CITY OF ALBUQUERQUE

November 10, 2020

RE: **Lot 2 Block 10 Unit 18 Volcano Cliffs**
6508 Picardia Pl. NW (S.A.D. 228)
Grading and Drainage Plan
Engineers Stamp Date 10/30/2020 (D10D0003P2)

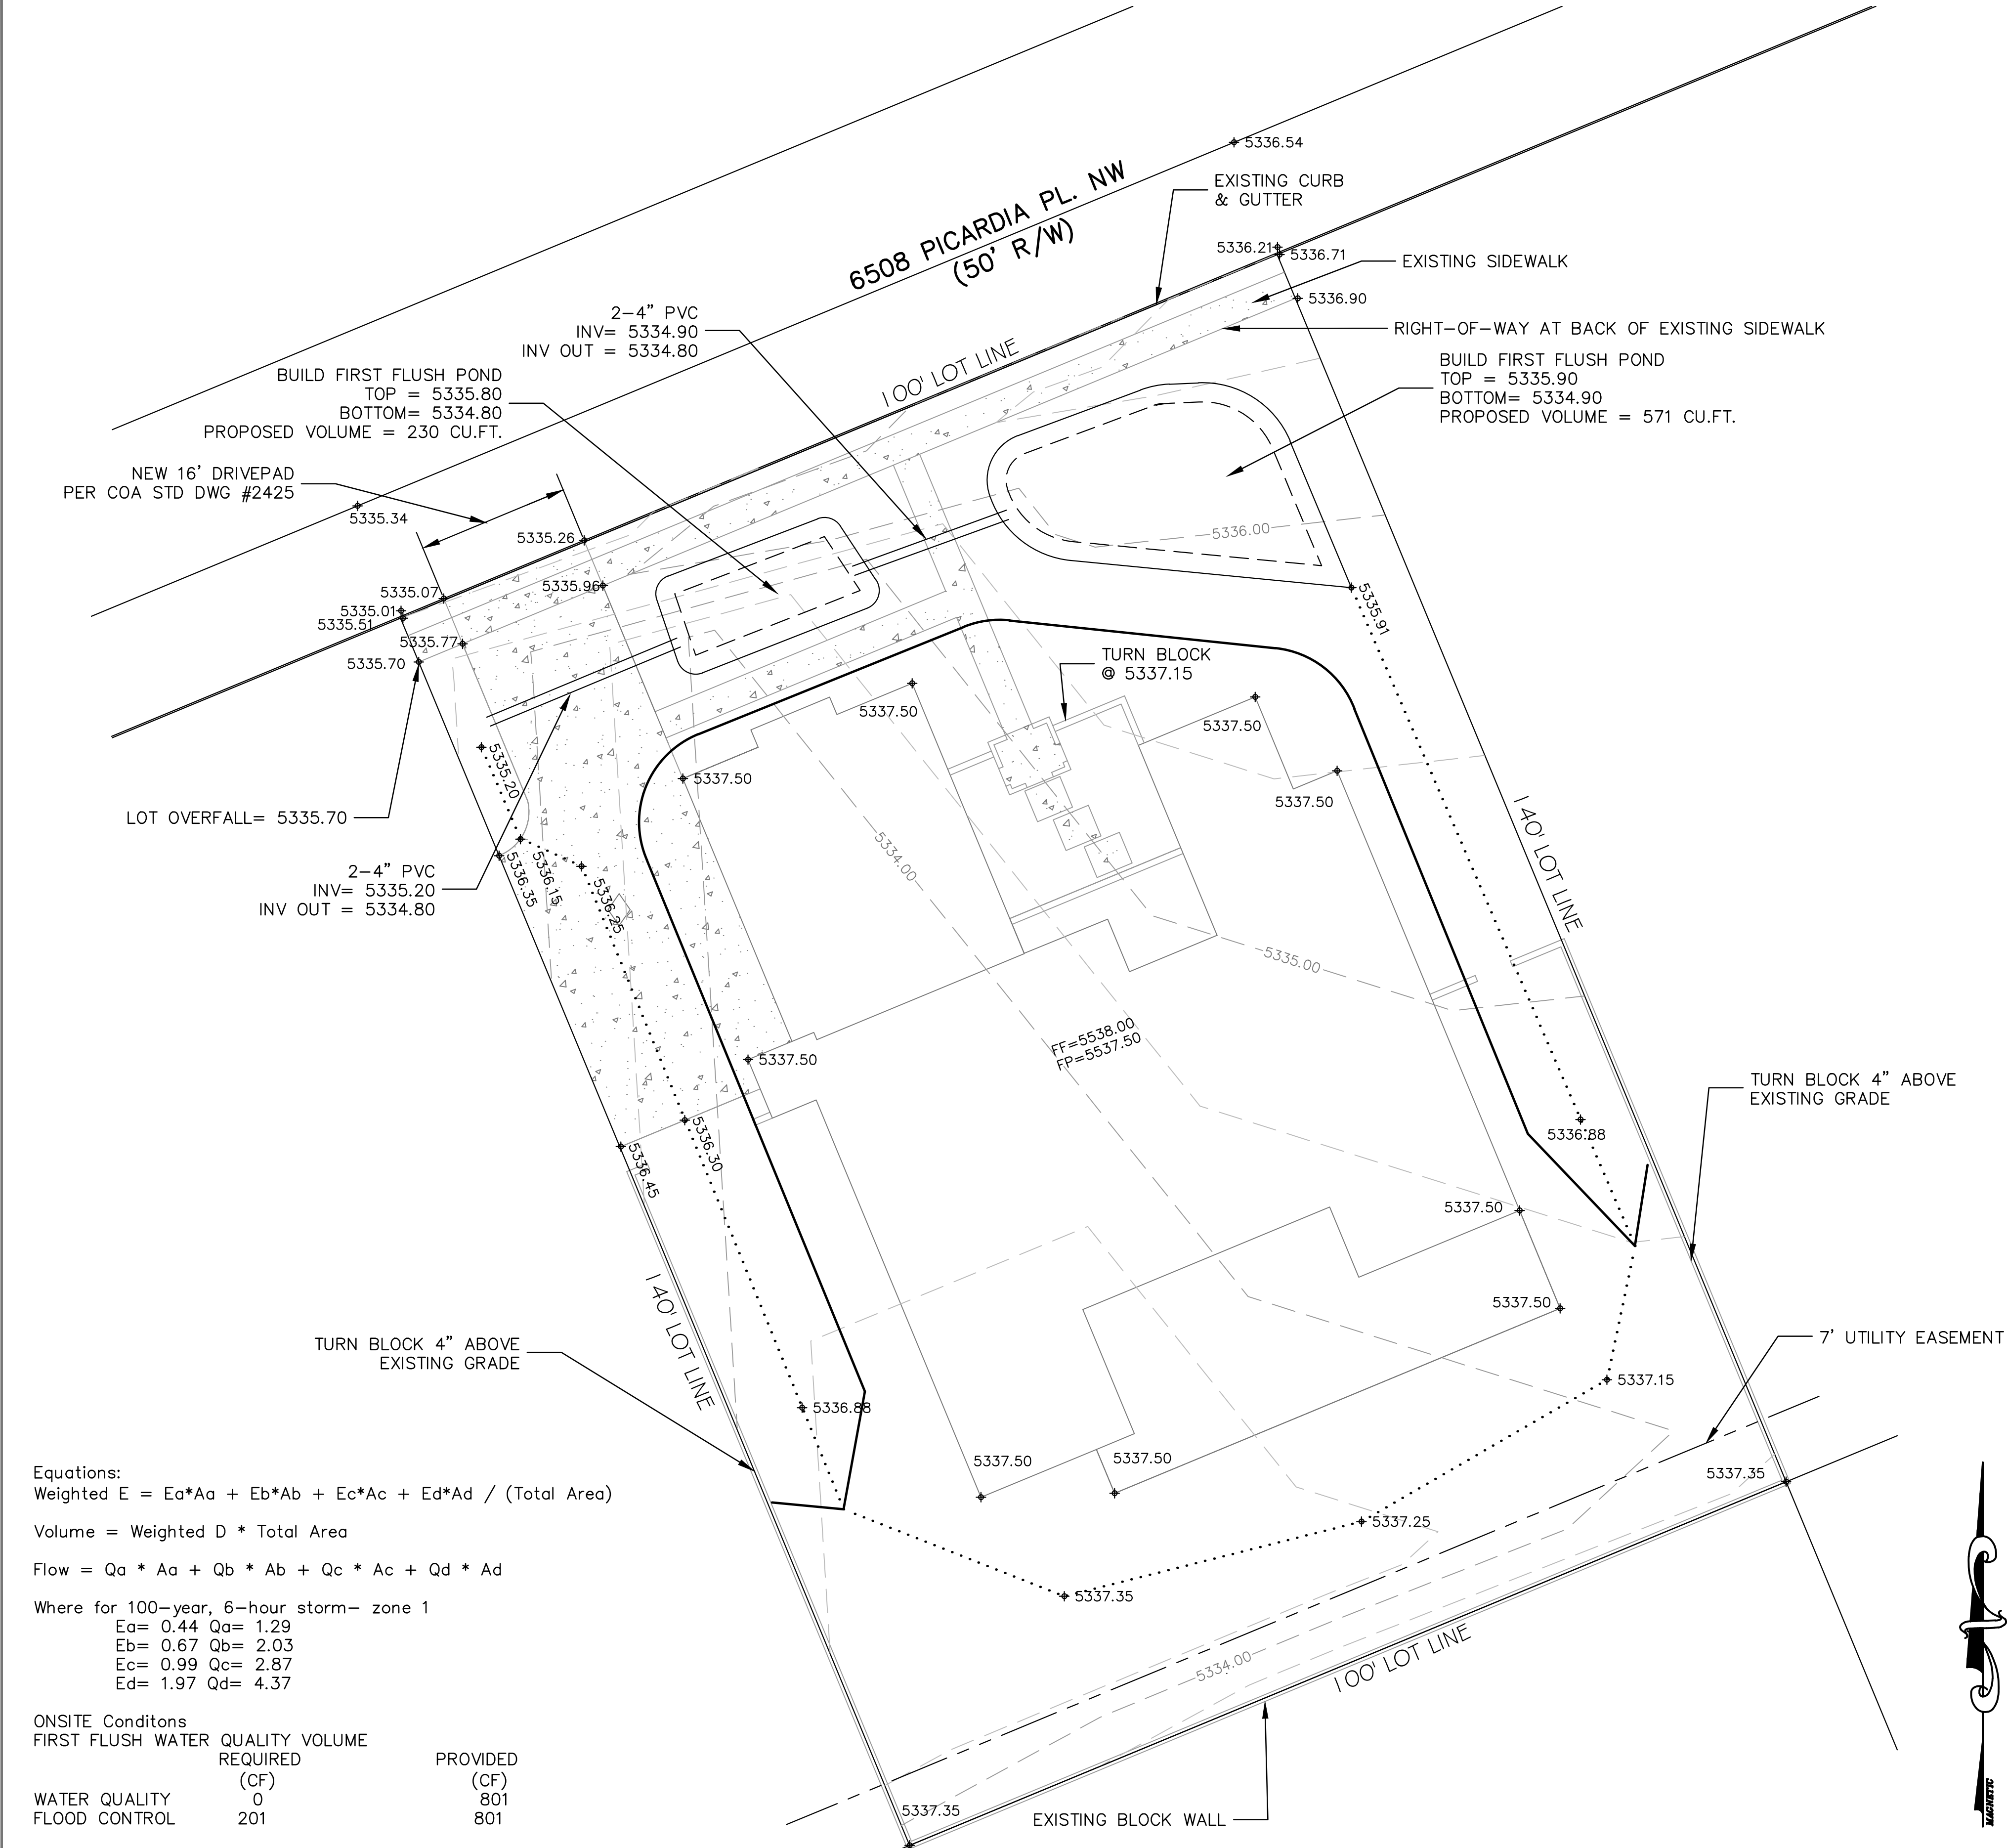
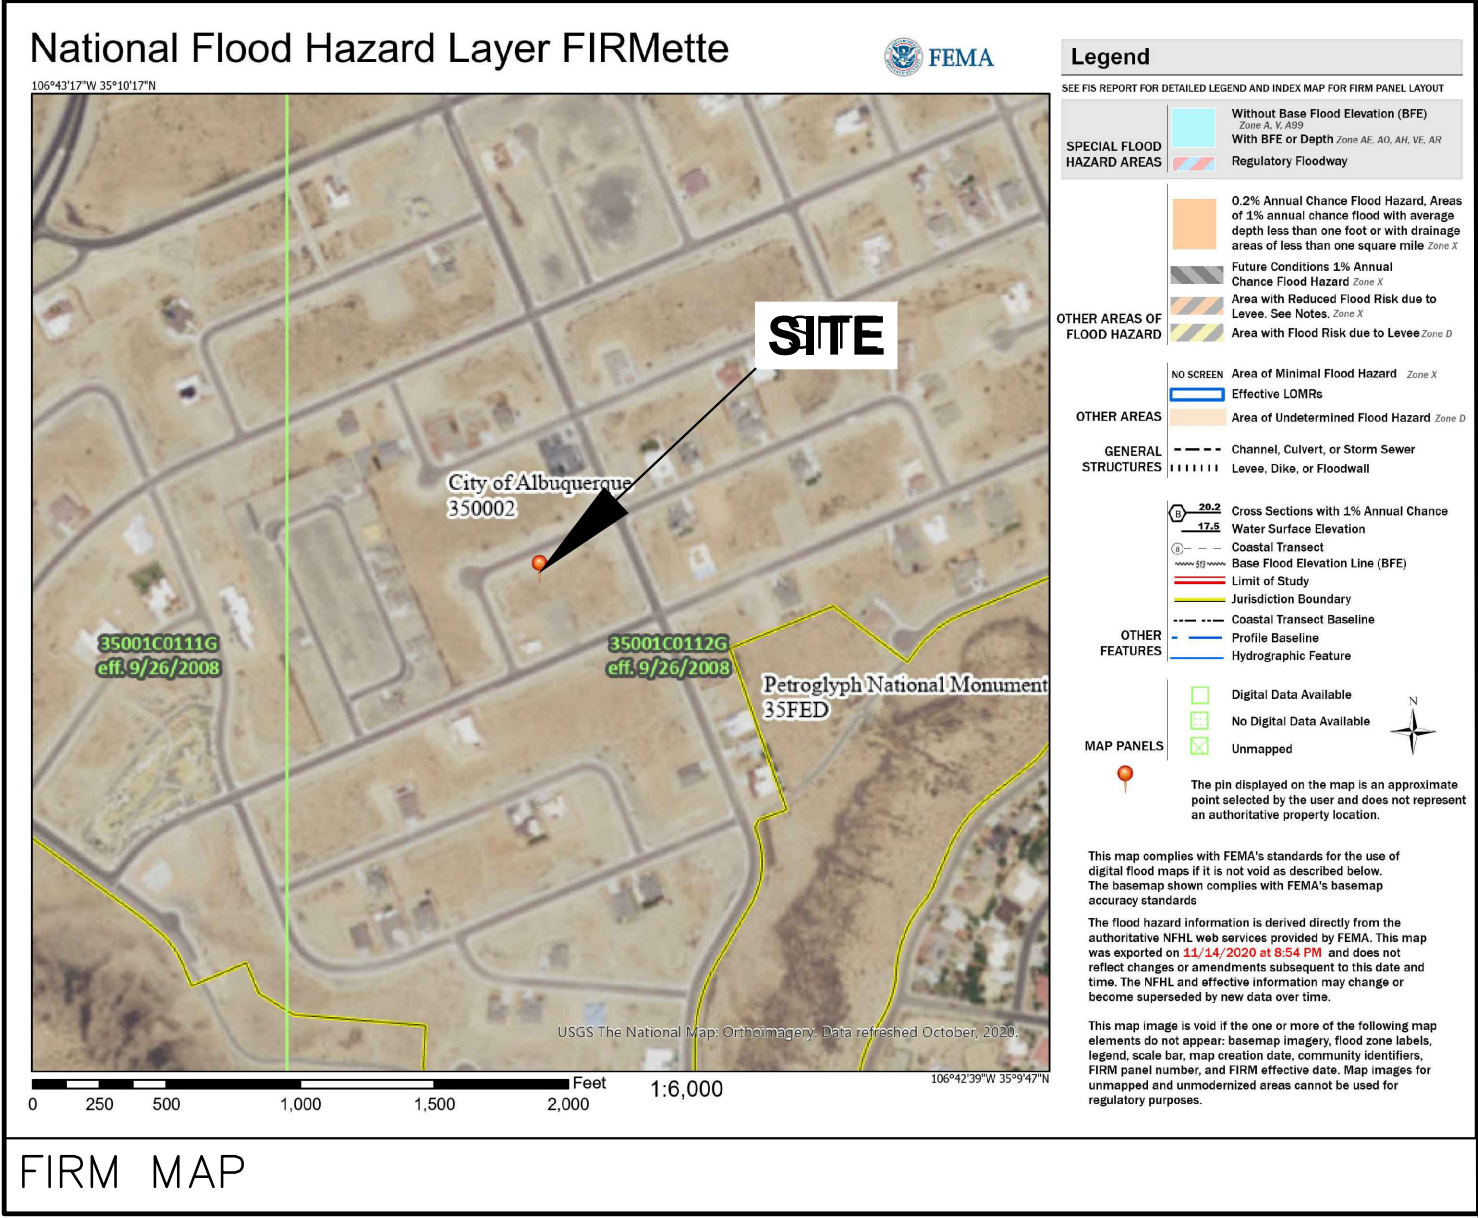
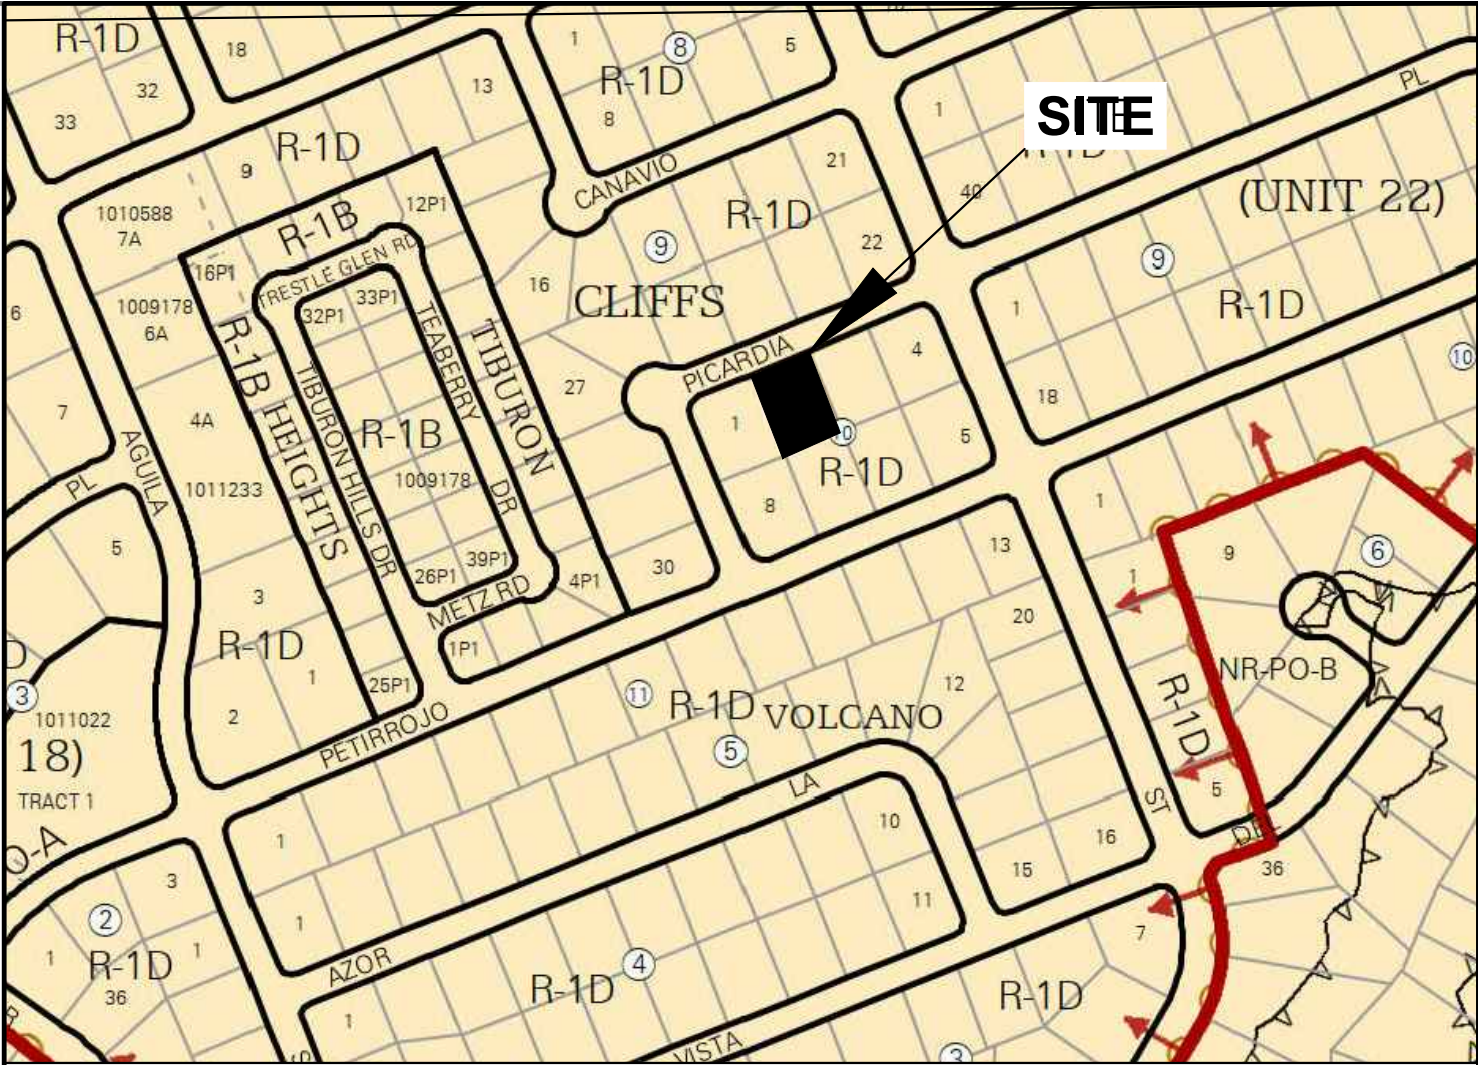
- Provide the land treatment calculations; look at SAD228 requirements for this area.
- Show the 7' PUE in the rear yard. If a garden wall is built turn blocks should be provided 3" above finish grade.
- Provide a site map and label construction site..
 - Provide a statement that a pad certification is required before a Building Permit is released.
 - Provide a statement that the block fence requires a separate permit and the approved grading plan must be provided with the plan set and permit.
 - This area requires a grading permit, a pad certification and a C.O.
